**REQUEST**

Current Zoning: N1-A (neighborhood 1-A)  
Proposed Zoning: N2-A(CD) (neighborhood 2-A, conditional)

Approximately 9.24 acres located at the dead-end of Jenkins Avenue and along the west side of Wright Avenue.

The petition proposes to develop up to 93 single family attached residential homes on a vacant parcel located between Walker Road and Craig Avenue, north of Sharon Amity Road.

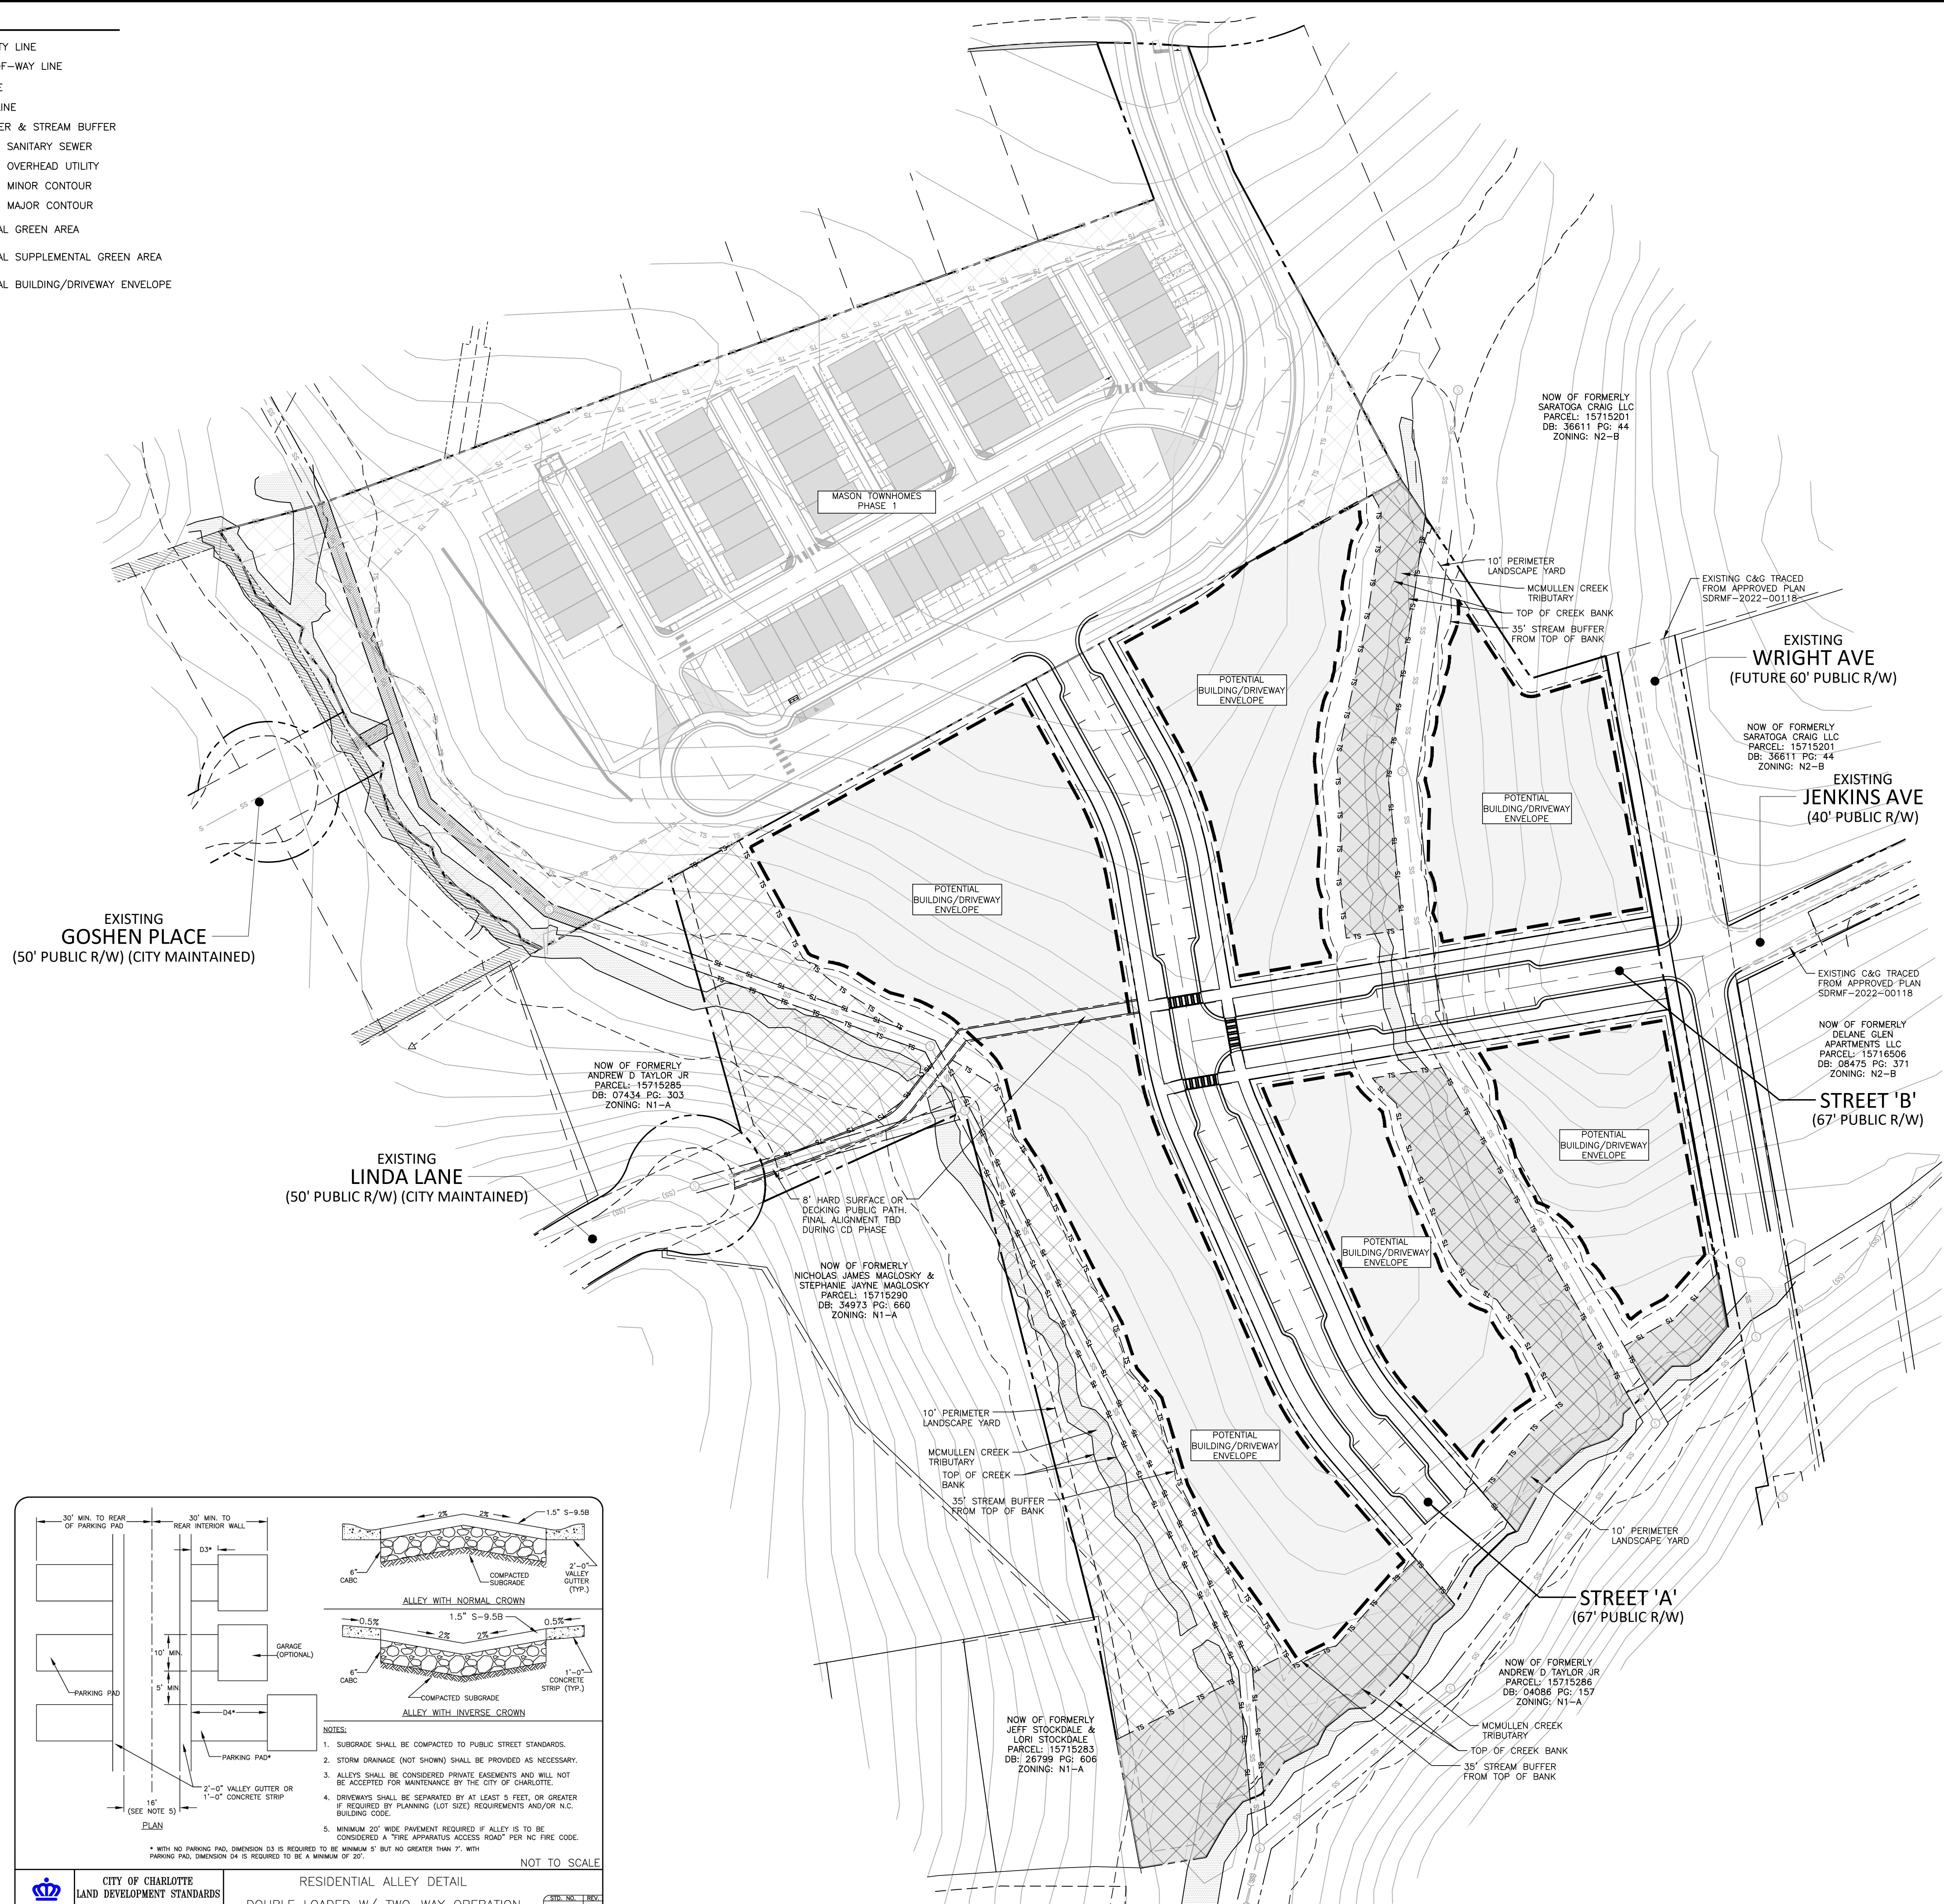
1. We recommend adding the following note under Environmental Features: "Petitioner agrees to provide 100-yr stormwater peak control or provide a downstream analysis using the criteria specified in the SCM Design Manual."
2. When construction plans are submitted for Land Development review, a 100+1 Stormwater Protection Analysis (100+1 Flood Study) will be required for all streams/creeks on site. It will also need to be shown that this development will create no adverse impacts to adjacent properties on the other side of the creeks.

3. Green area is broken up into too many sections (max of 3) Please review the Charlotte Tree Manual for guidance.

4. Revise site plan to include a temporary turnaround for Street A. Since "Street A" is a dead-end road, this will require a turn around. See CLDSM 11.18A for reference.
5. CDOT requests that the petitioner commit to upgrading the southern portion of pavement section along Jenkins Avenue east of the proposed development. An existing townhome development is committed to upgrading the northern portion of Jenkins Avenue.

6. Please confirm if the petitioner is removing the public path to Bridlepath Lane.
  7. Recommend improving Jenkins Ave to public street standards so that it can be publicly maintained. Coordinate with the project SDRMF-2022-00118 Jenkins Townhomes to improve Jenkins Ave to public street standards.
  8. Clearly label streetscape along Wright Avenue and commit to all streetscape improvements in development notes.
-
